City of Albuquerque Stormwater Construction Site Inspection Report

Project Name:	Maverik				
Location:	650 Juan Tabo				
Site Contact Name & Agency	Jason - Insight Const	ESC File No.	K22E059		
	jason@insightnm.com	NPDES Id. No.	NMR10022L		
Inspection Date:	12/10/19	Start/End Time:	1000/1020hrs		
CoA Stormwater Inspector:	Timothy E. Sims				
Construction Phase:	vertical				
Type of Inspection:	<input checked="" type="checkbox"/> Regular	<input type="checkbox"/> Storm Event	<input type="checkbox"/> Post Storm Event >0.25"	<input type="checkbox"/> 311/Complaint	<input type="checkbox"/> Follow Up

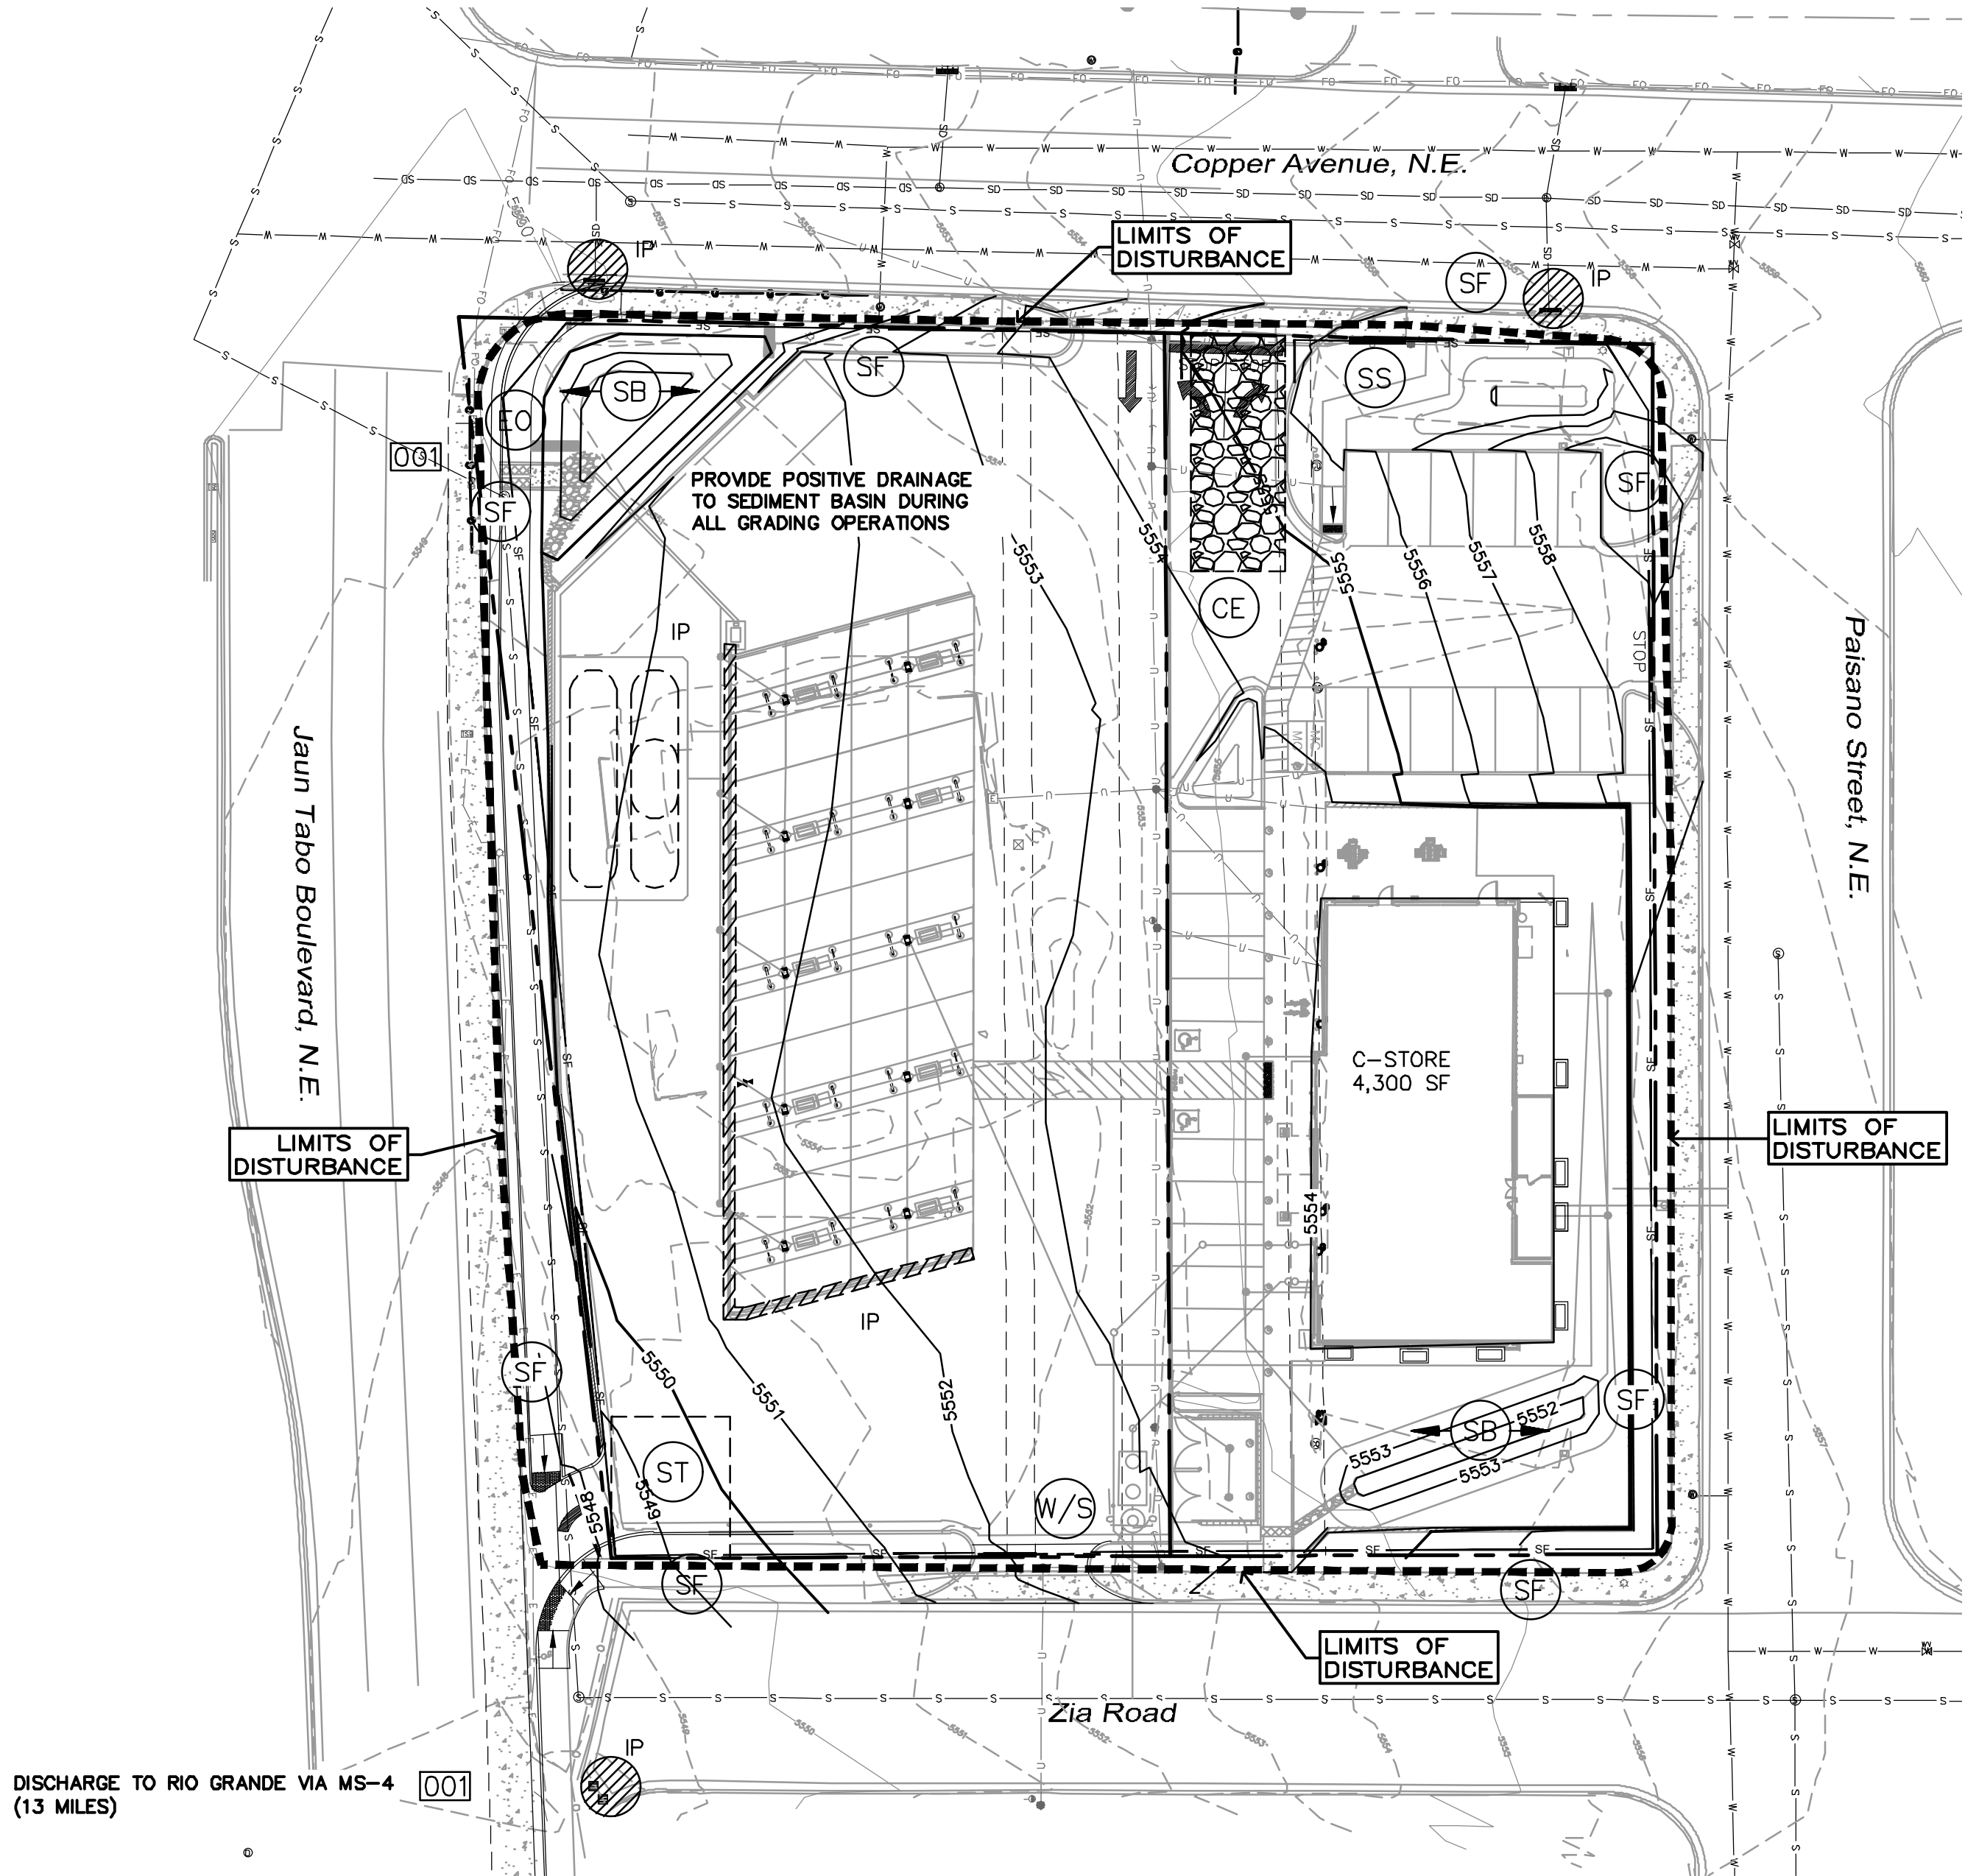
Item Number	Deficiency/ Corrective Action		
1	Sediment in streets: Paisano, Copper and Zia--(on Copper from Juan Tabo ~100' east of Paisano, on Paisano from Copper to ~75' south of Zia, and on Zia from ~100' East of Paisano to end of cul-de sac.) {see photos}		
2	Stock pile in Zia requires sediment BMP or removal from street.		
3	The track out pad on Zia requires mitigation.		
4	Dirt piled on silt fence on the west side of the site. Sediment must not exceed 50% of silt fence height.		
5	NW corner of site, dirt on top of mulch sock and mulch sock no longer functions as designed.		
6	Concrete washout facility: Cementous washout is leaking from container and requires mitigation.		
7	Copper construction entrance requires sediment BMP. Please mitigate.		
2.1	Discharge off site? (Y/N)	No	
4	Self Inspection Reports	requested	Latest report Date: 10/23/2019
